**From:** Brenda Larsen  
**Sent:** Wednesday, January 30, 2013 9:36 AM  
**To:** Jeff Watson  
**Subject:** RE: BL-12-00034 Arnott

Re: Arnott (BL-12-00034)

BOUNDARY LINE ADJUSTMENT SURVEY

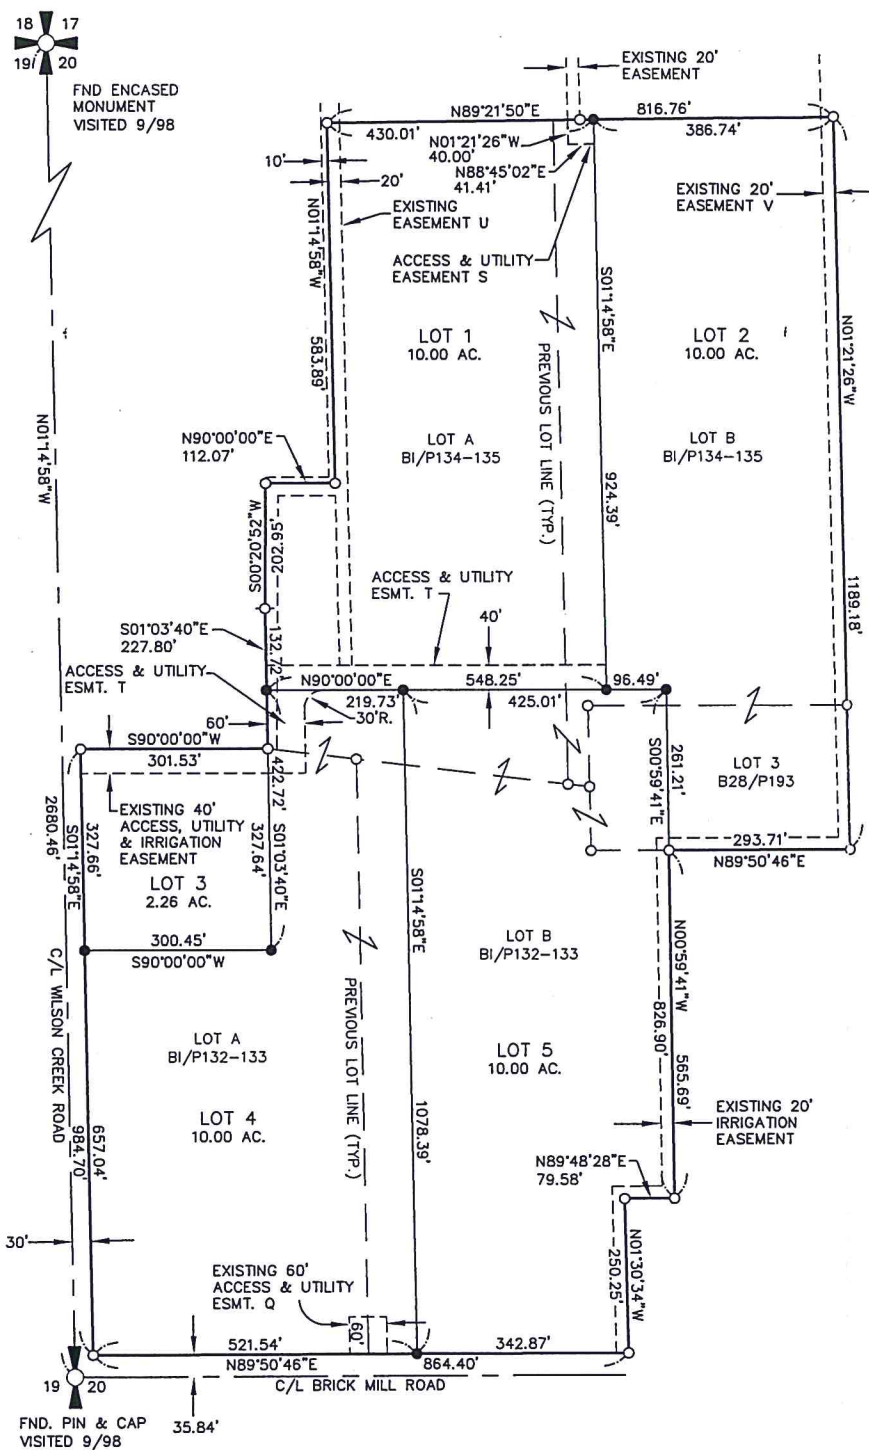
- Any new roads that are created are to comply with Kittitas County Road Standards and the International Fire Code.
- Ensure that boundary line adjustments do not infringe upon existing structures, to include propane tanks, etc.
- All future development must comply with the International Fire Code.
